Summary Transcript from Issue Specific Hearing 5 Environmental Matters & Highways

18 February 2021

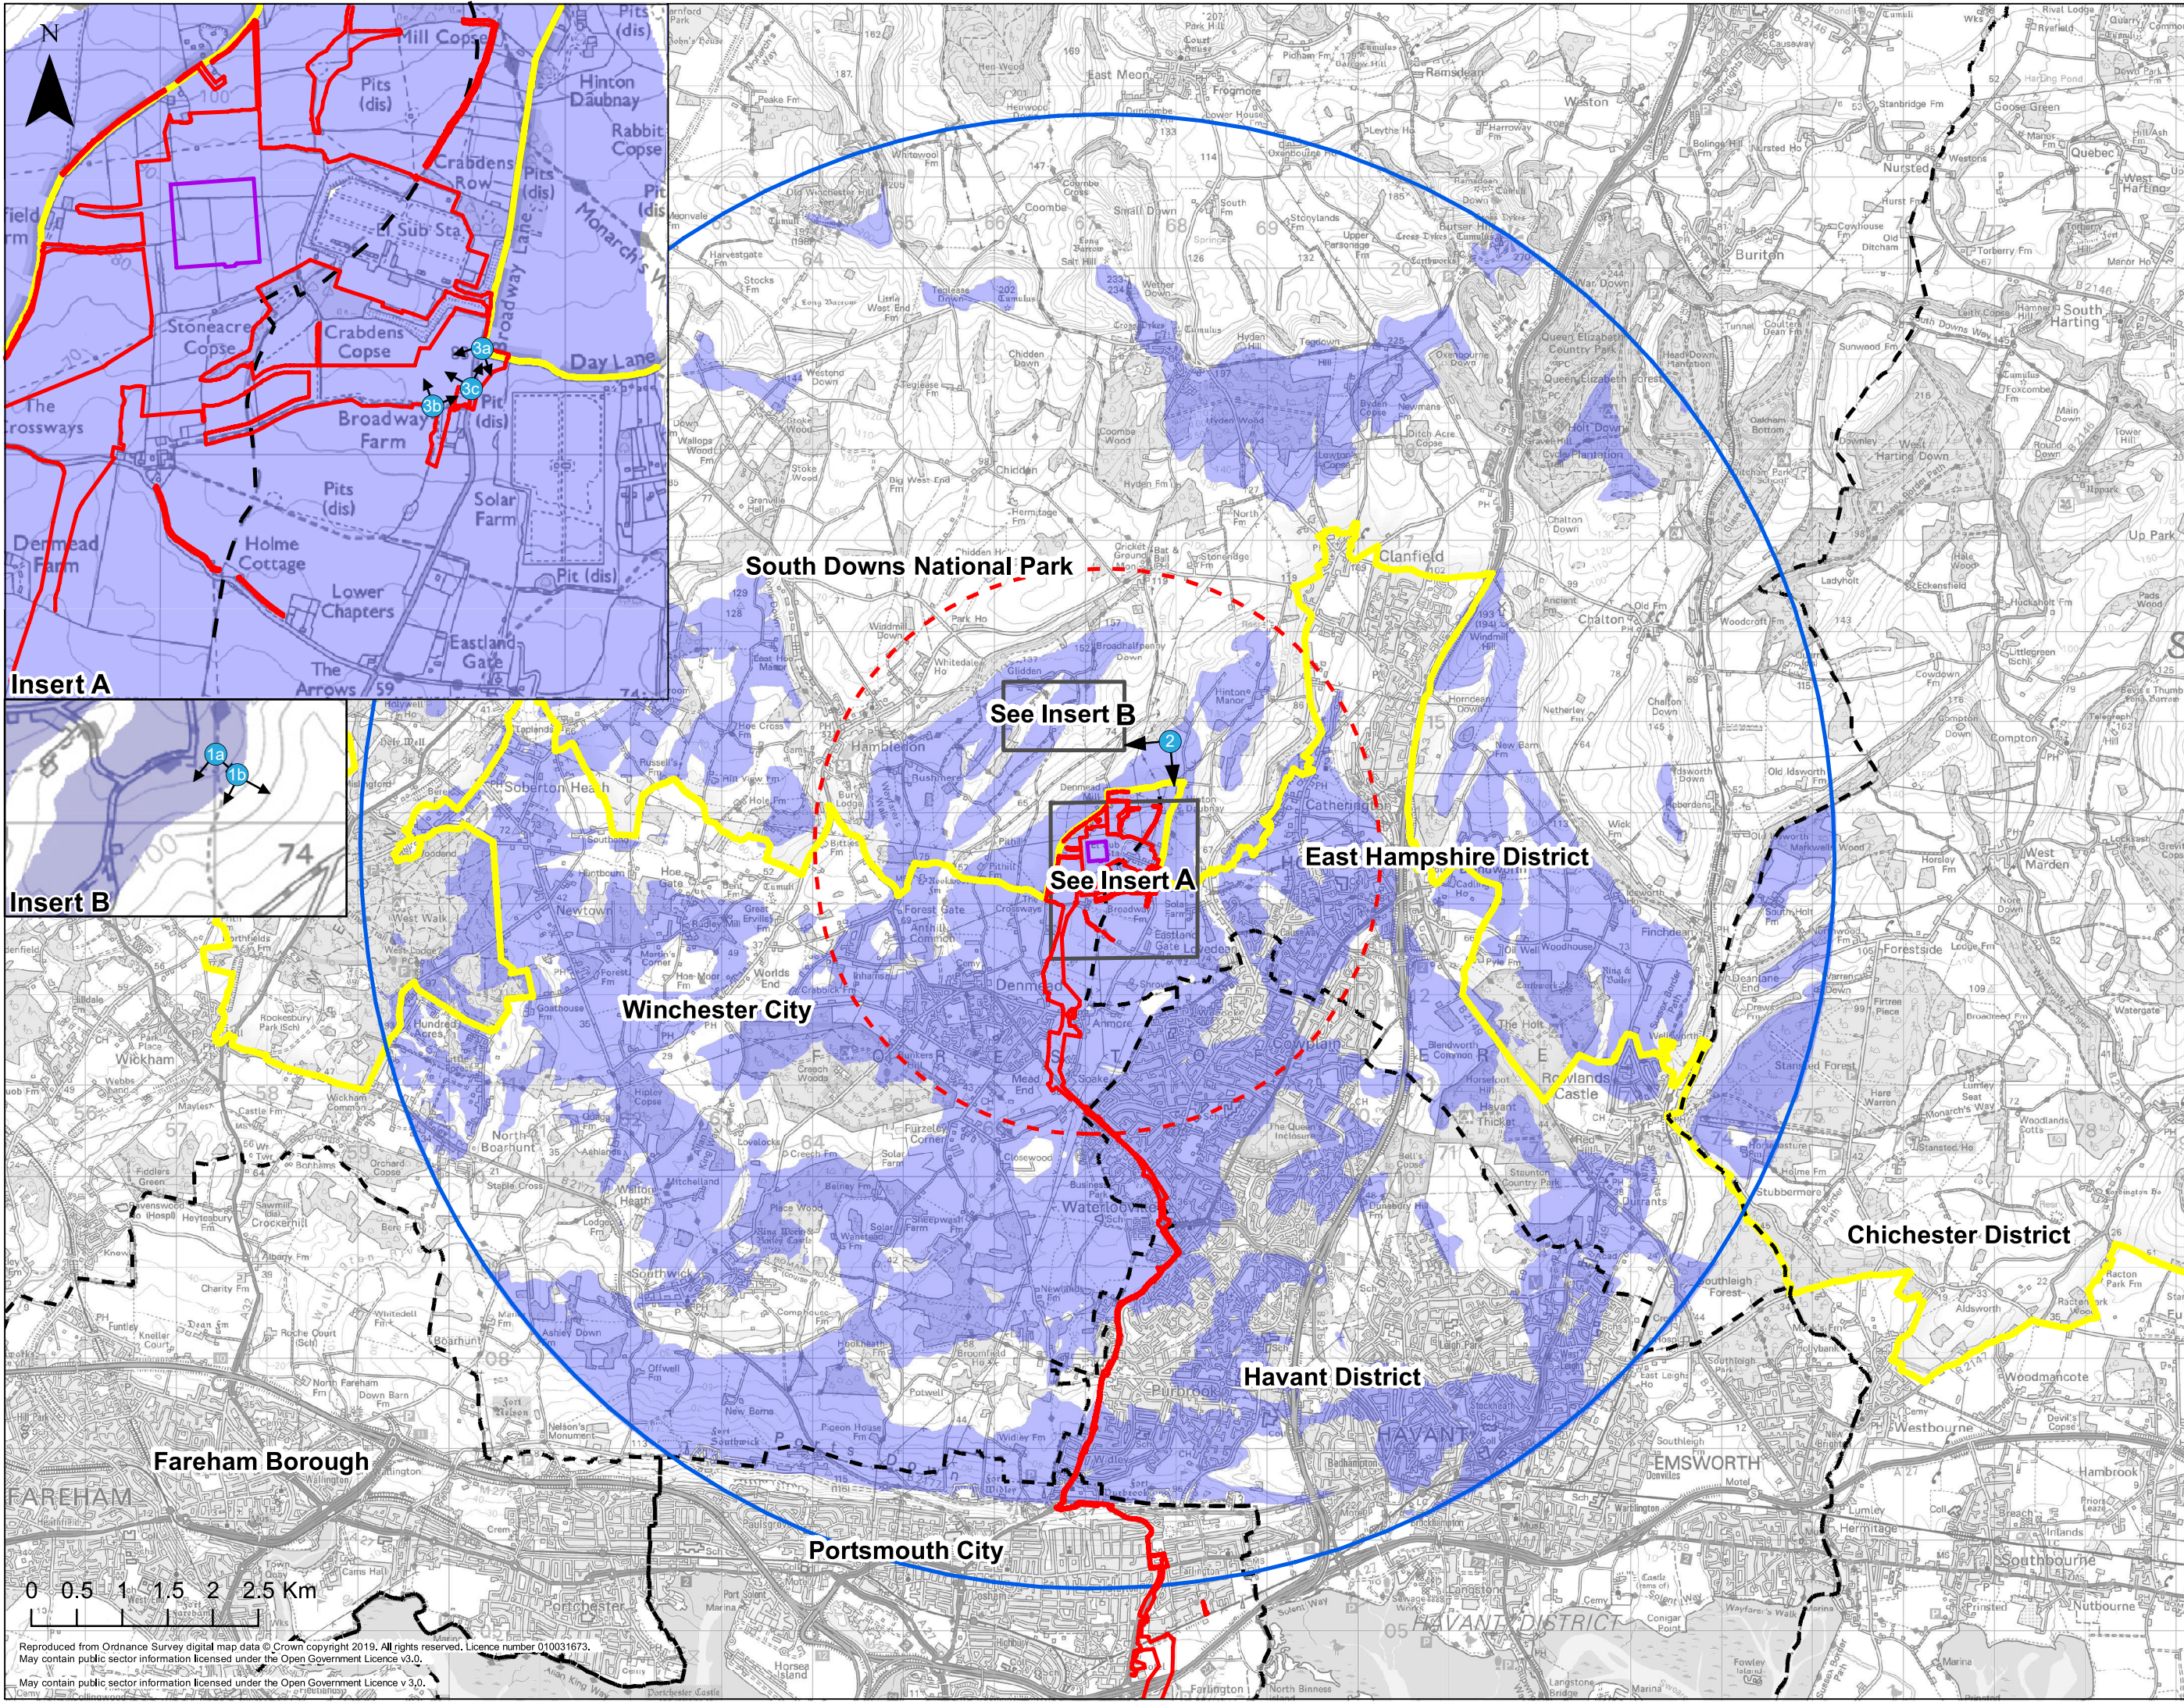
The only thing I *had not appreciated* was that one of the SDNP's requested VP's (Rep 063: Fig 15 61 B and C **VP3**) was to try and illustrate the visual impact that the *new site access* would have at the junction with Day's Lane. Nothing to do with the Converter Station itself. The CS would not be visible from this point.

However, I cannot really comment on this as I have seen no indication of what form the new access might take. I am anticipating this would be part of the detail submission.

Postscript: The latter observation on VP3 relates to a situation outside the Winchester City Council area as the impact is limited to around the proposed access point.
